**New Liverpool Primary School (SSD-10391)
Response to submissions report**

Attachment 1 – Key Issues

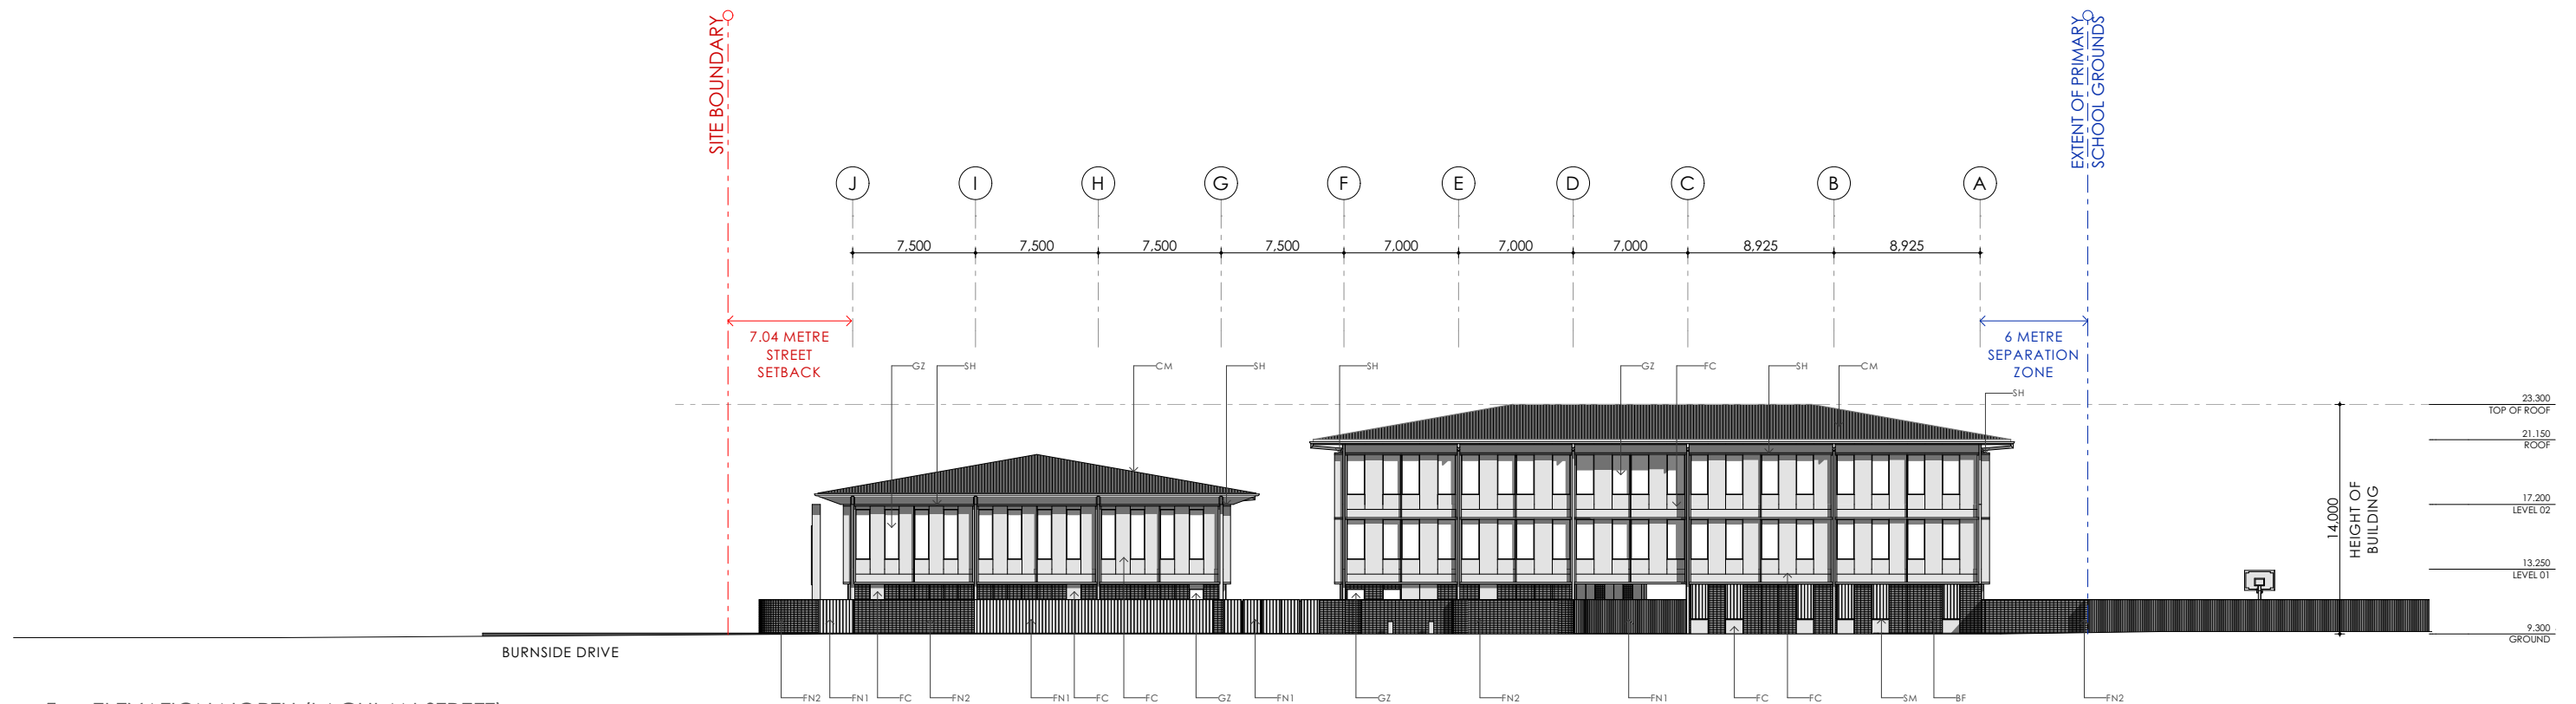
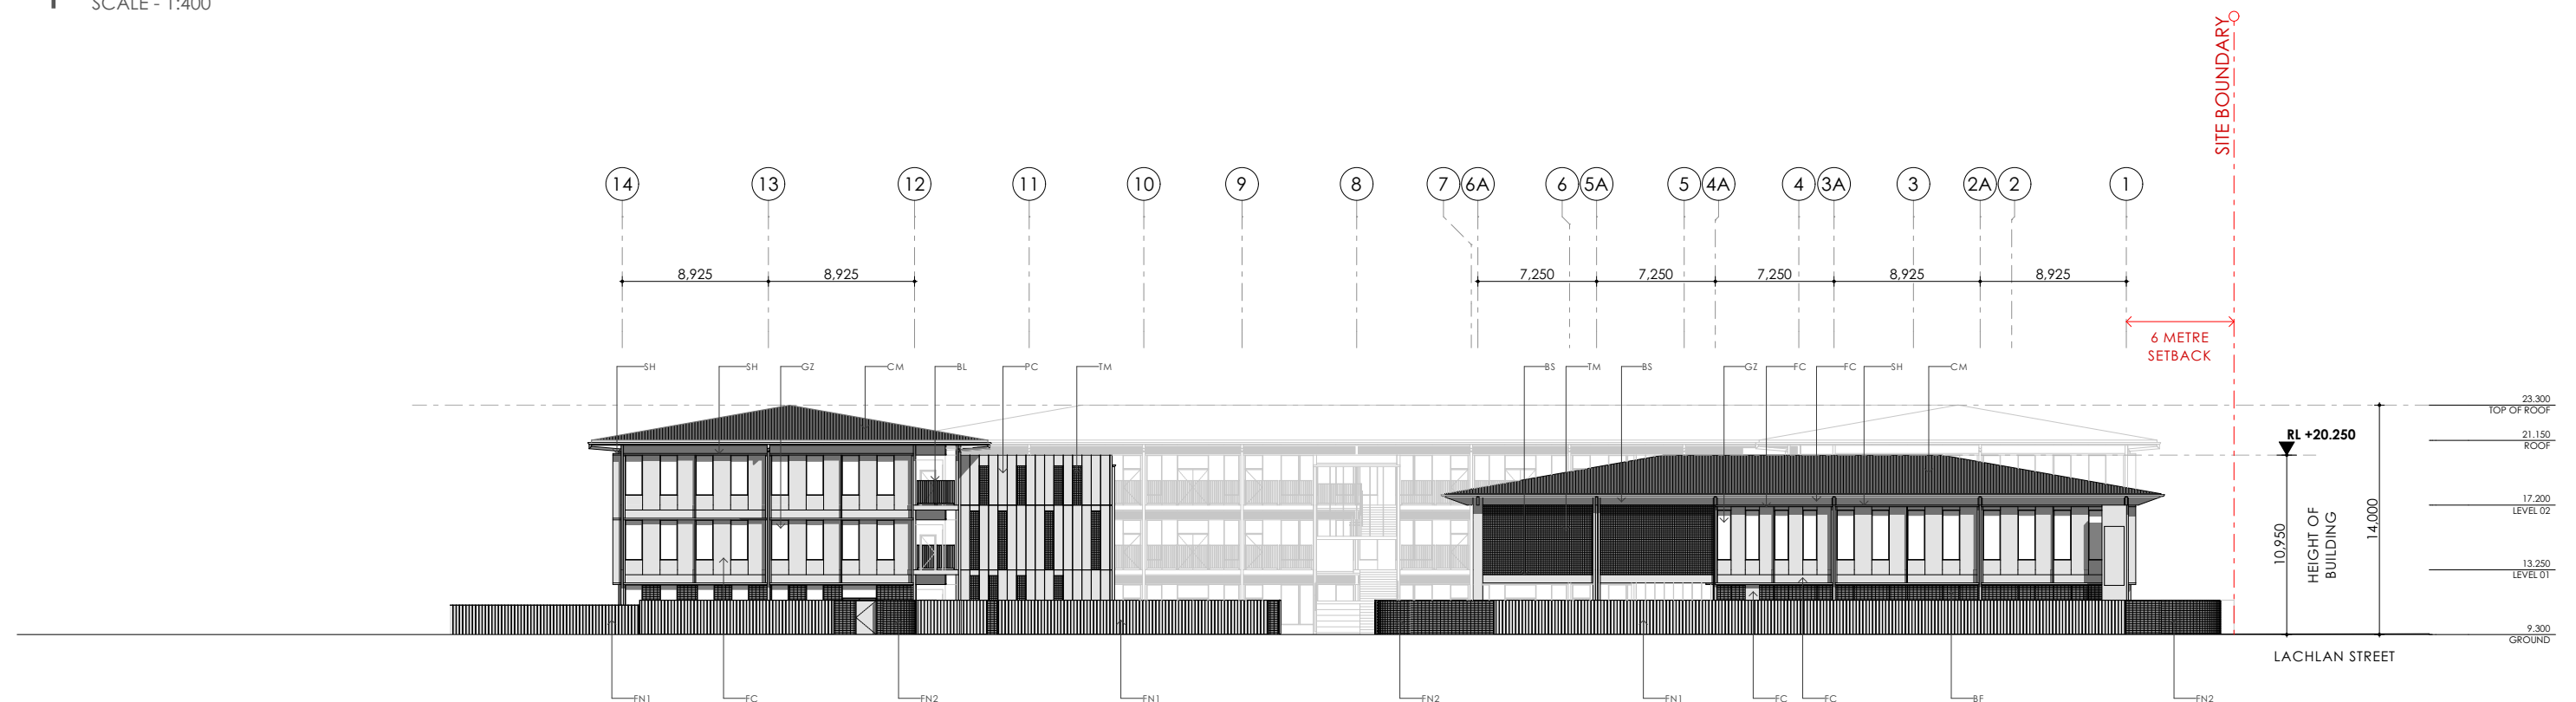
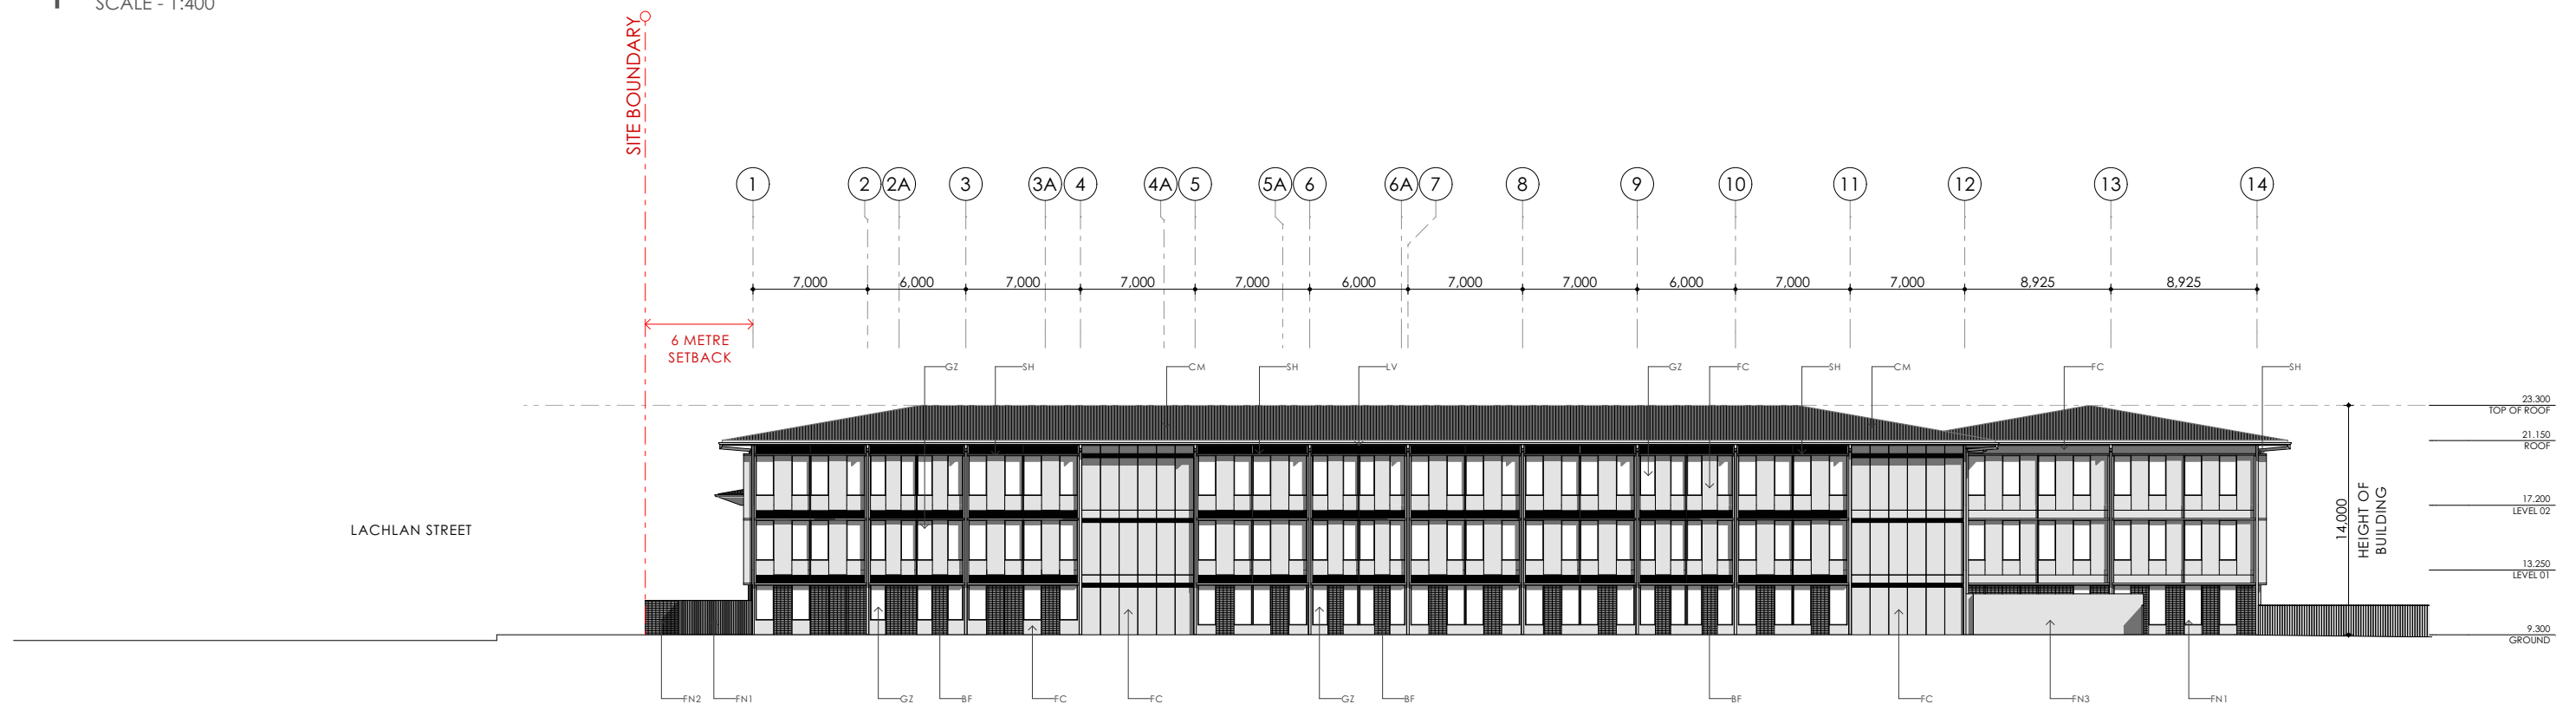
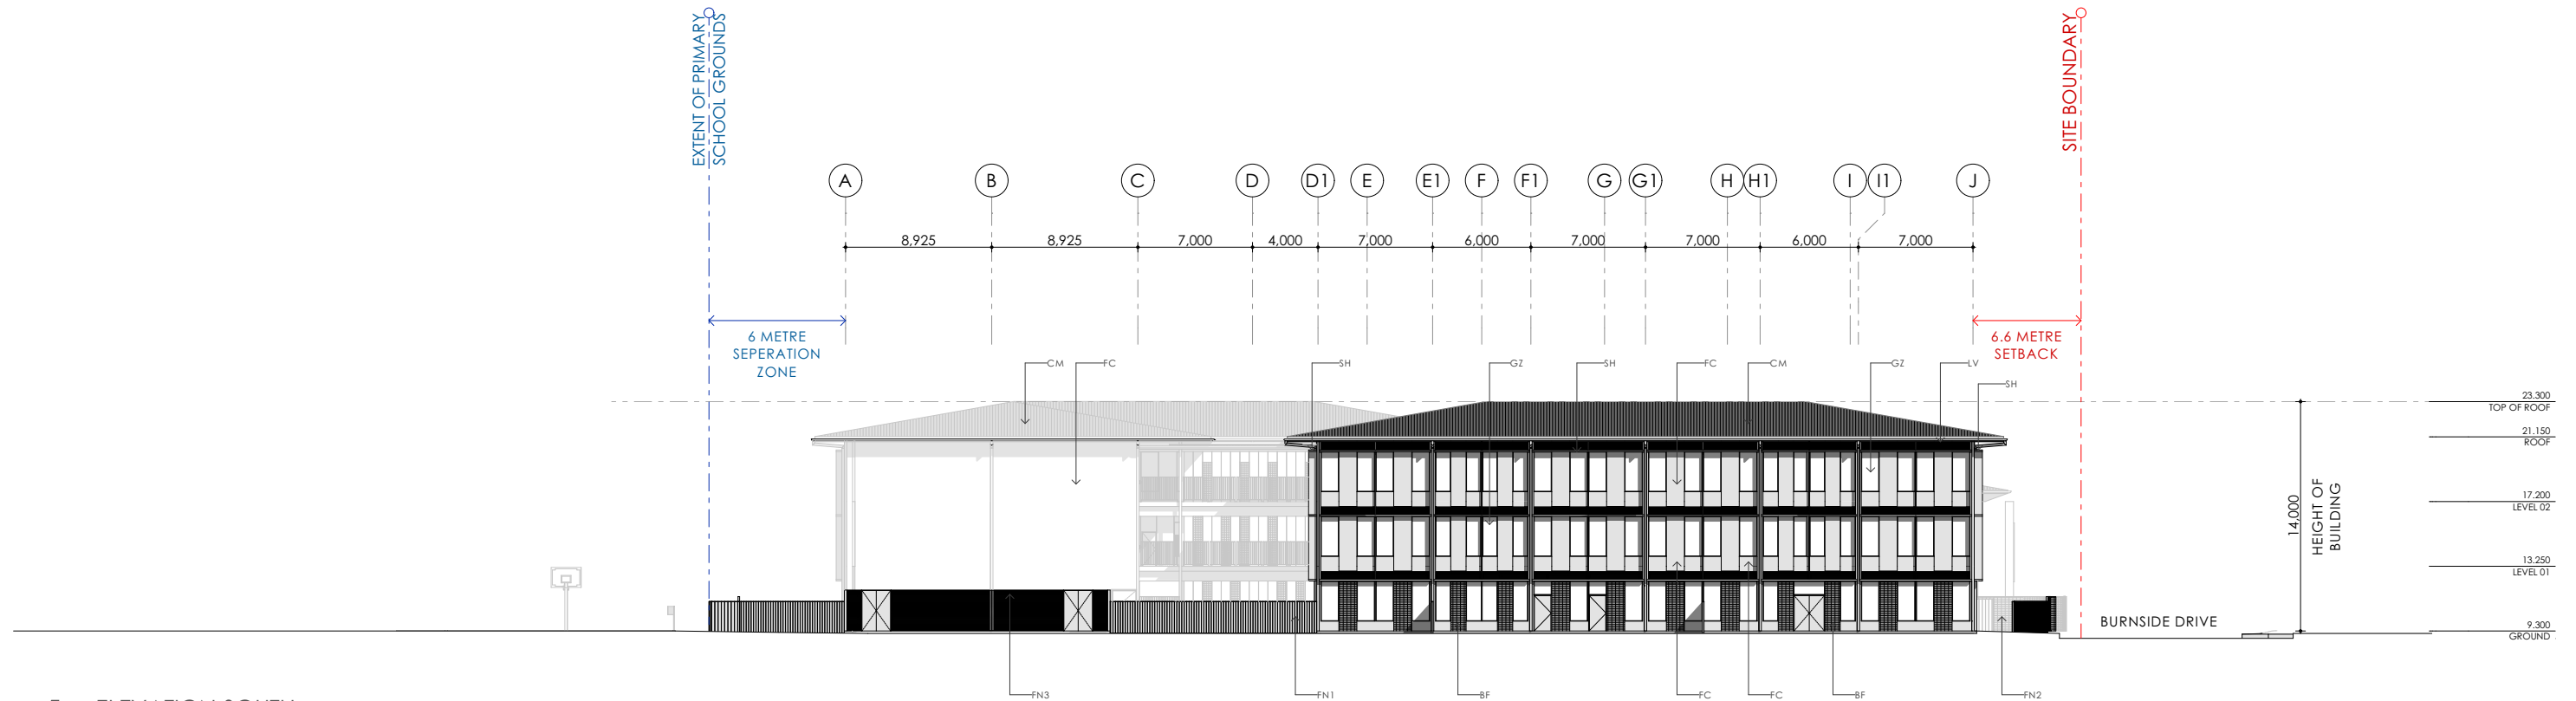
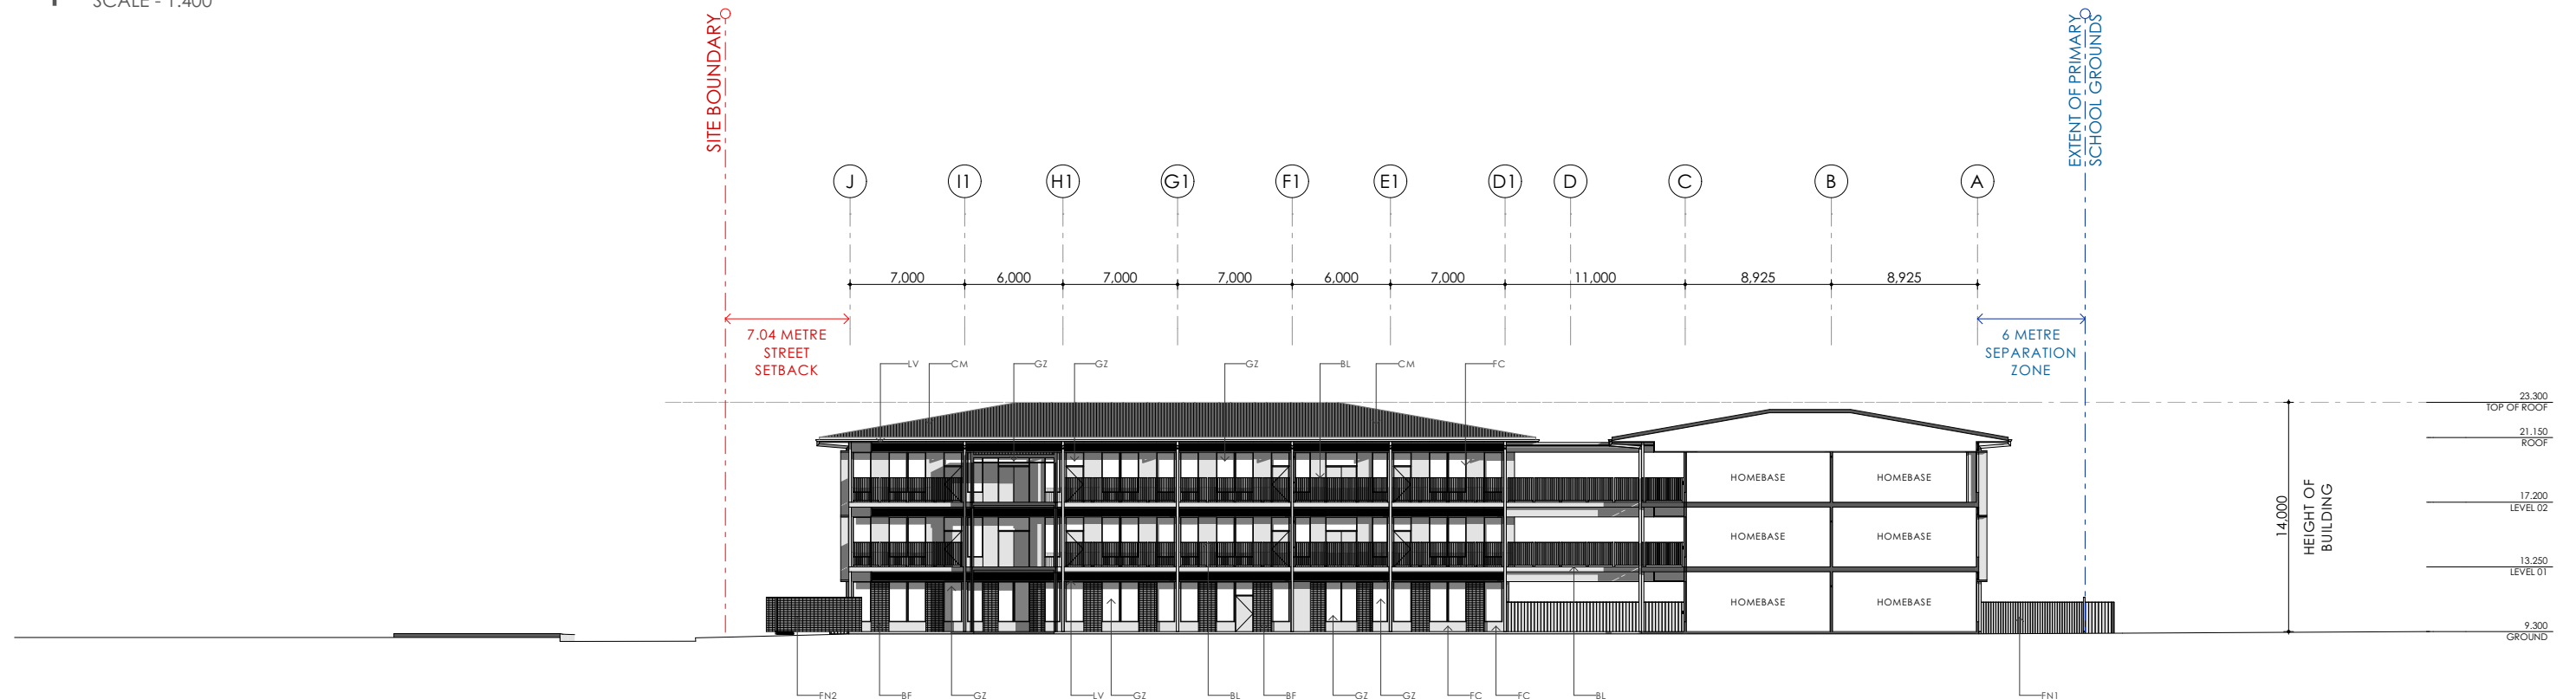
- Government Architect NSW (GANSW) have reviewed the EIS and have raised concerns regarding the full height glazing to the Western façade with no shading and no planting able to be facilitated along the boundary. In recognition of the western elevation, you are requested to address this issue and provide additional shading devices or articulation of this façade which can result in shading.
- Please provide details on the proposed future east/west link through the site, even if it is not finalised as yet, to demonstrate the site permeability.
- GANSW have raised concerns that the 'breakout' balconies have been deleted with only one outdoor learning space on level 01. You are requested to address this issue, include reasons as to why all of the upper level balconies have been deleted and provide details of outdoor learning areas on this level.
